**Ivanhoe Estate Redevelopment – Concept (SSD 8707)
EPA comment on Response to Submissions**

I am writing to you in reply to the invitation to the Environment Protection Authority (EPA) to provide comment on the Response to Submissions (RtS) for the Ivanhoe Estate Redevelopment – Concept.

# Ivanhoe Estate, Macquarie Park - Epping Road Boundary: Sunday 17 September, 2017

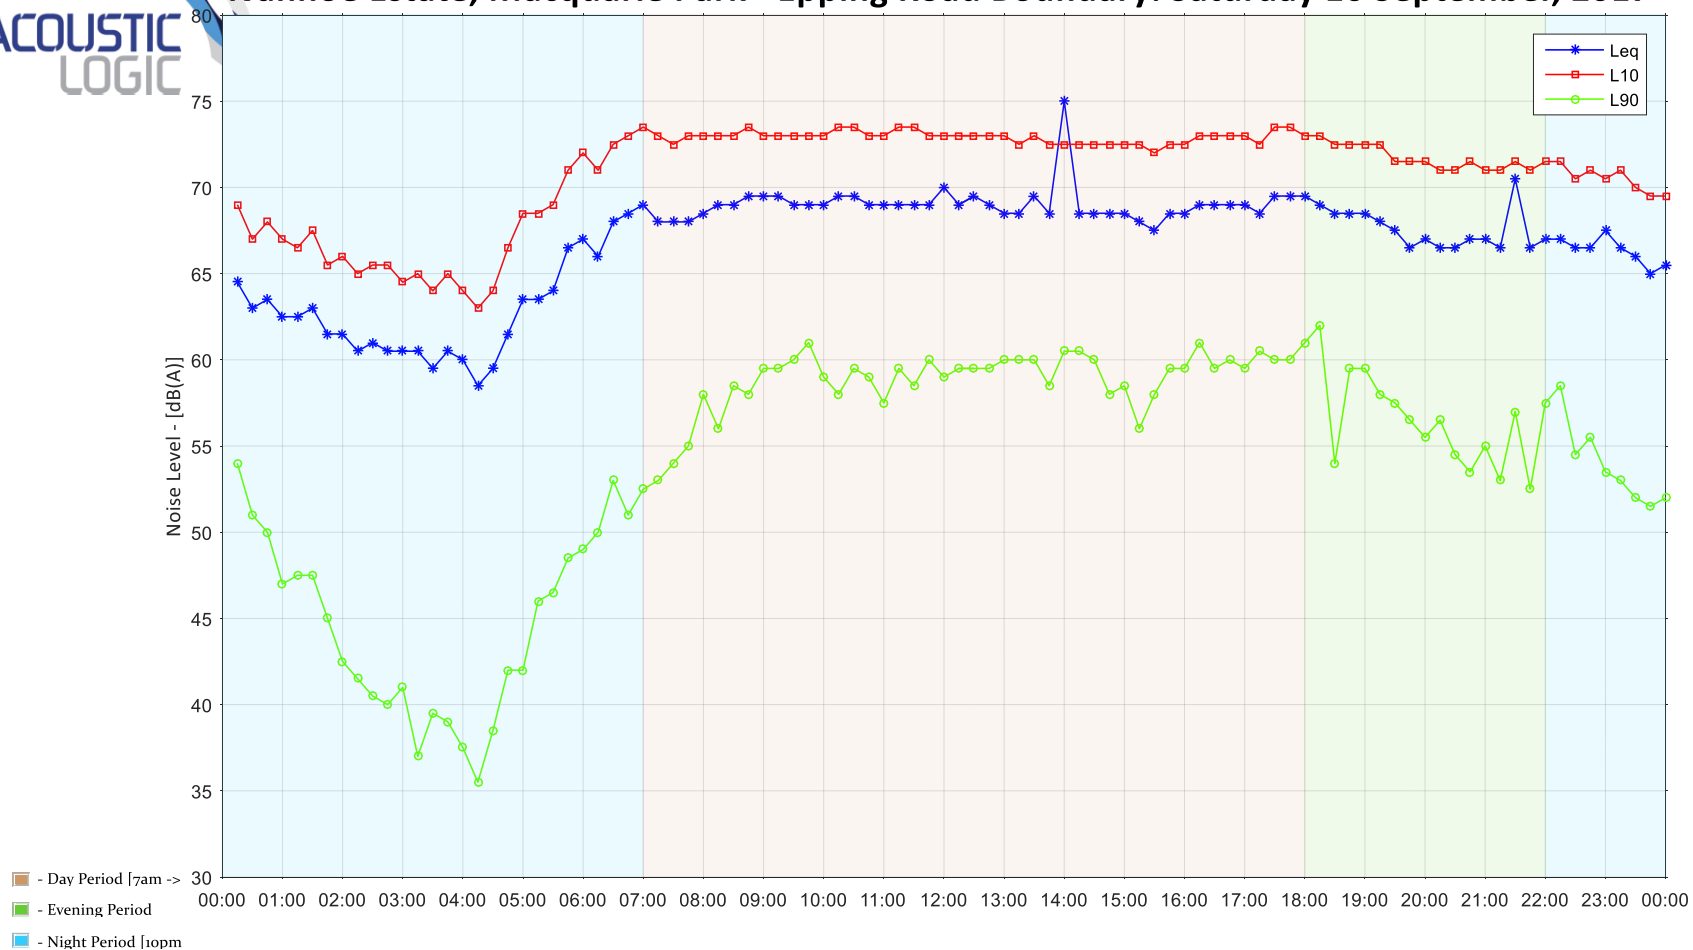
- Further to this, some of the measurement data presented in Table 1 of the Acoustic Logic letter has been removed due to adverse weather. However, this has been done inconsistently. For example, measurements at Location 2 and Location 5 were carried out over the same time period in September 2017, but data from different periods have been removed. Inconsistencies are also apparent with Locations 4 and 6, undertaken over the same period in October 2017. There are six periods removed for Location 4 which were not removed for Location 6, without explanation. It appears that this was due to adverse weather data, and therefore it is not clear why this data was removed at one location and not the other. No explanation was provided in the information submitted.

- Wind and rain data have been included on the monitoring graphs in Appendices 1 to 6 of the revised RtS noise report, however the location and source of the data has not been included.
